**From:** [Guymer, Tim](#)  
**To:** [Aquind Interconnector](#)  
**Cc:** [Oliver, Lewis](#); [Maguire, Ian](#); [Stickland, Caroline \(Solicitor\)](#)  
**Subject:** Aquind Interconnector Preliminary Meeting - HBC, PCC & HCC response on Agenda Item 3  
**Date:** 01 September 2020 16:48:53  
**Attachments:** [Aquind DCO prelim mta HBC PCC HCC response to Issue 3.pdf](#)

**AQUIND Interconnector Examination Preliminary Meeting -  
Havant Borough Council, Portsmouth City Council and Hampshire  
County Council's response to Agenda Item 3 Initial Assessment of  
Principal Alternatives**

**Plate 2.9 - DC Cable Route Options (Feb 2017)**

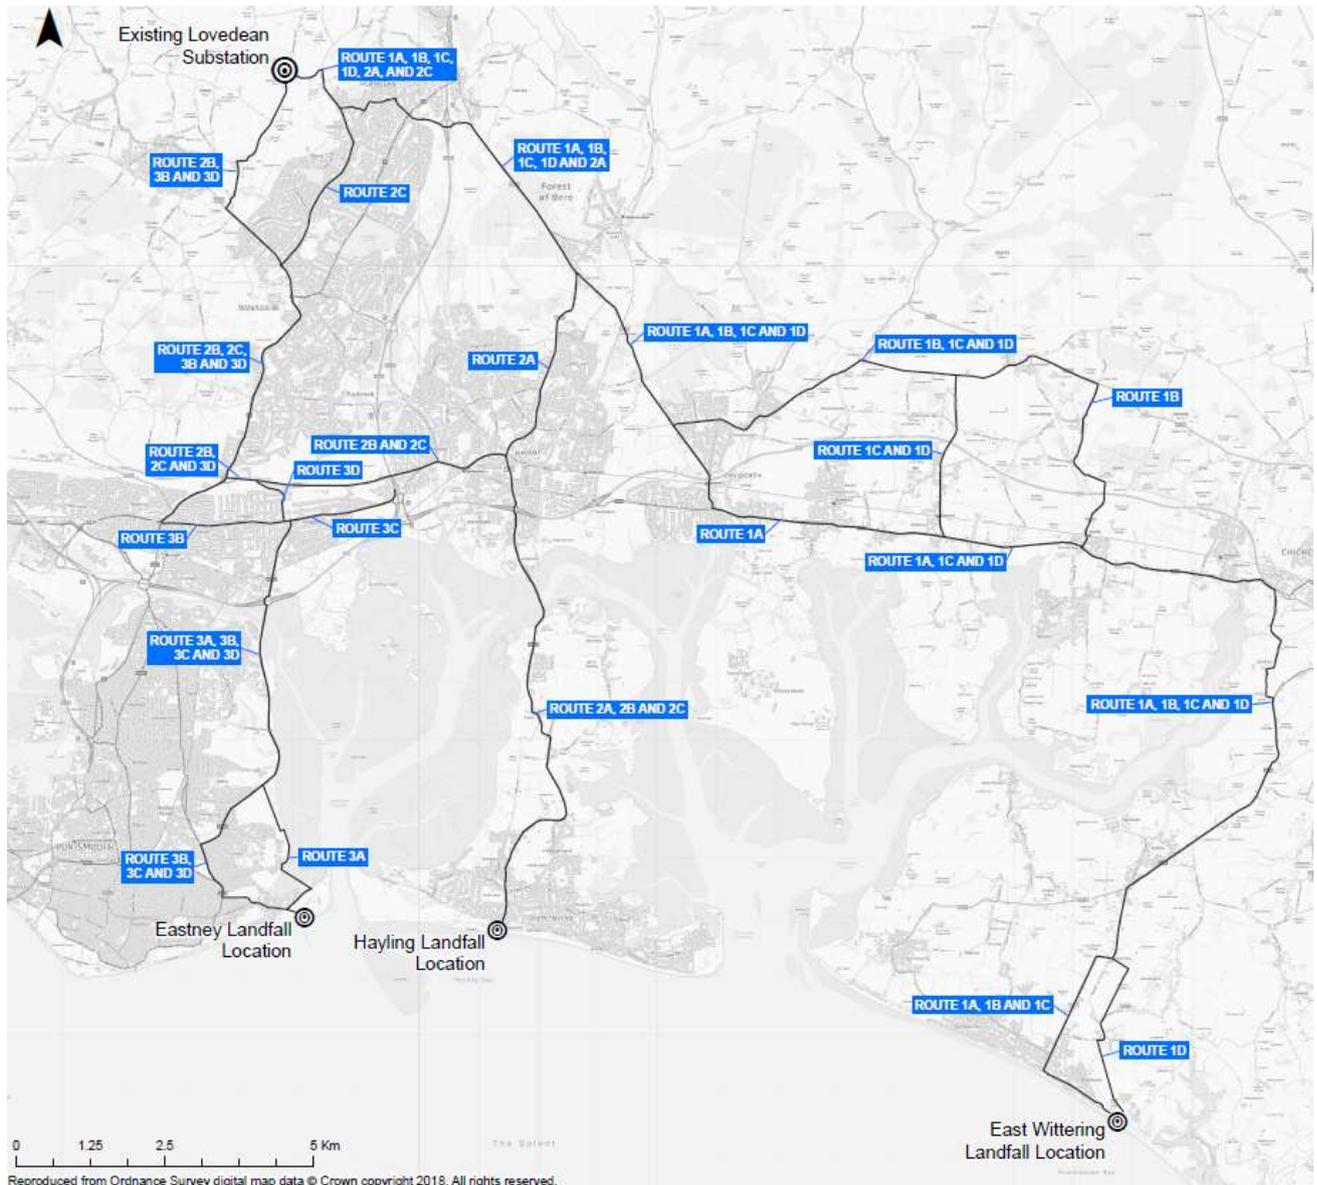
The routes from these landfall points to Lovedean are show on Plate 2.9 (DC Cable Route Options). They all show the cables being laid in the highway, emphasising the prior early decision taken by the applicant to utilise the road network and not appraise a cross-country route.

Section 2.4.11.5 does refer to consideration being given to shortening sections of the cable route by going off road across fields, but the primary approach was to look for routes following the road network. In the

assessment of the Eastney Portsea Island landfall to Lovedean option, no indication is given of the consideration of a cross-country route west of the A3.

**Plate 2.10 - Cable Route 3D (blue) and Cable Route 1D (pink)**

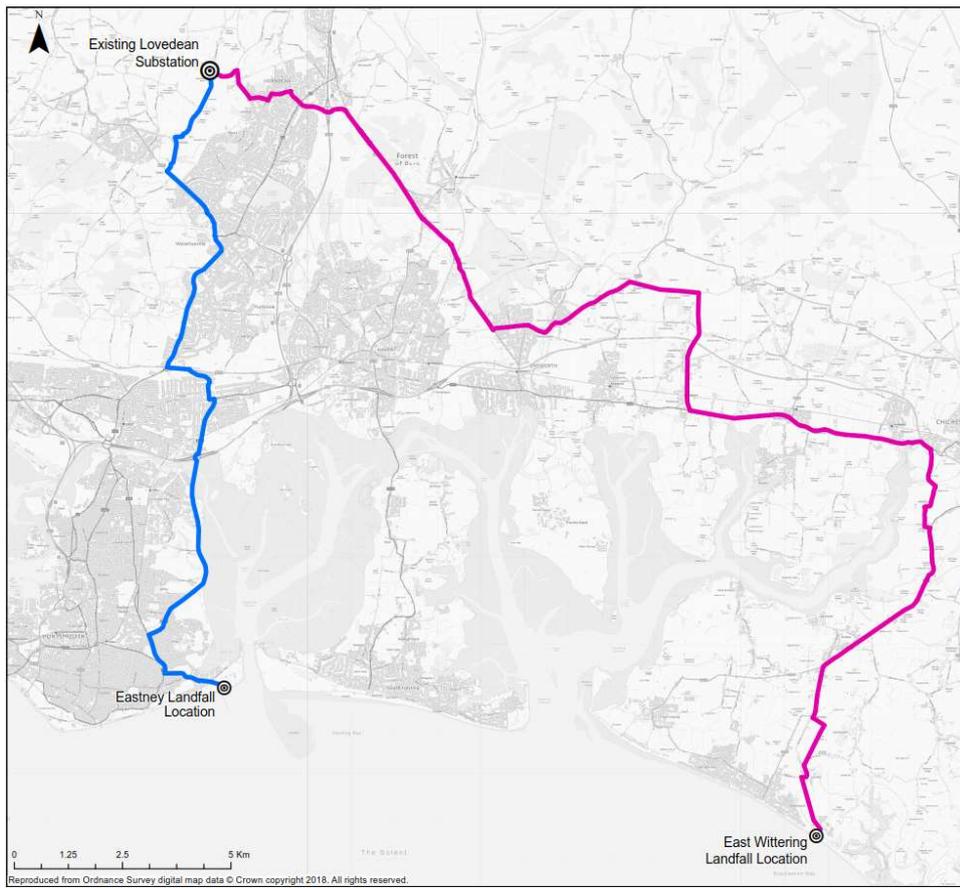
Section 2.4.13 (UK Cable Routes Detailed Desk Studies of Route 1D & 3D) June 2017 indicates that a further assessment of the Eastney to Lovedean cable route was made. The section makes no reference to the consideration of the cross-country route being assessed against the road route. Again, this appears to reflect the "strategic" choice made by the applicant.

**Plate 2.13 – Alternative Countryside Routes (as proposed by WCC and HBC)**

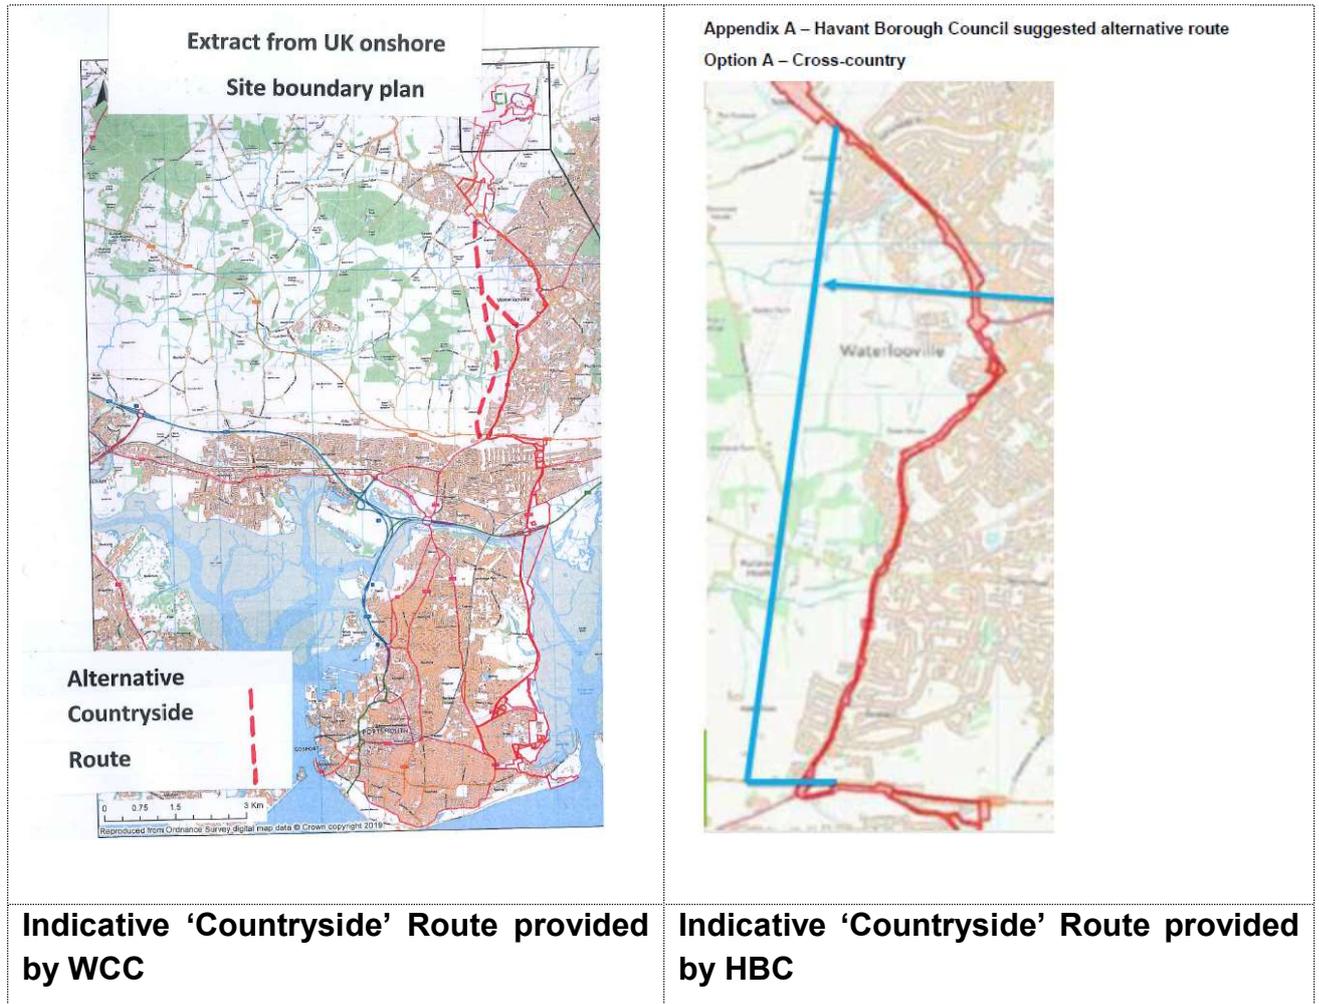
Section 2.6.4 outlines the response to the WCC and HBC Alternative Countryside Route which those authorities raised in their responses of April 2019 to the PEIR consultation exercise. Two comments are made in response to this section.

Firstly, this is the only point in the submission at which point the applicant addresses the cross-country route. The optioneering process is silent about any consideration of the cross-country route prior to this section. It seems likely that had the two councils not raised it in their responses to the PEIR then the ES may well have been totally devoid of any reference to it.

Secondly, the table as presented in 2.6.4 is not a fair assessment of the two options one against the other. It is not a straightforward process considering the environmental impacts of a countryside route compared to that following an urban route. The countryside option is highly likely to score higher on environmental impacts. What is lacking is a more detailed analysis beyond the simplistic observation that there will be some "temporary short-term impact on traffic" (2.6.4.5) if the road route is followed. Just as the Environmental impacts are listed in the table so the socio-economic impacts need identifying and weighing. These should include covering the potential delays to traffic including emergency vehicles and the potential to inhibit future work to maintain or enhance the road network or service future development through the presence of the cables in the road. Other impacts, such as the potential impact on highway trees have yet to be appraised. The fact the applicant has not explored these in a greater level of detail and that the level of impact is still emerging is viewed as a deficiency in the process.
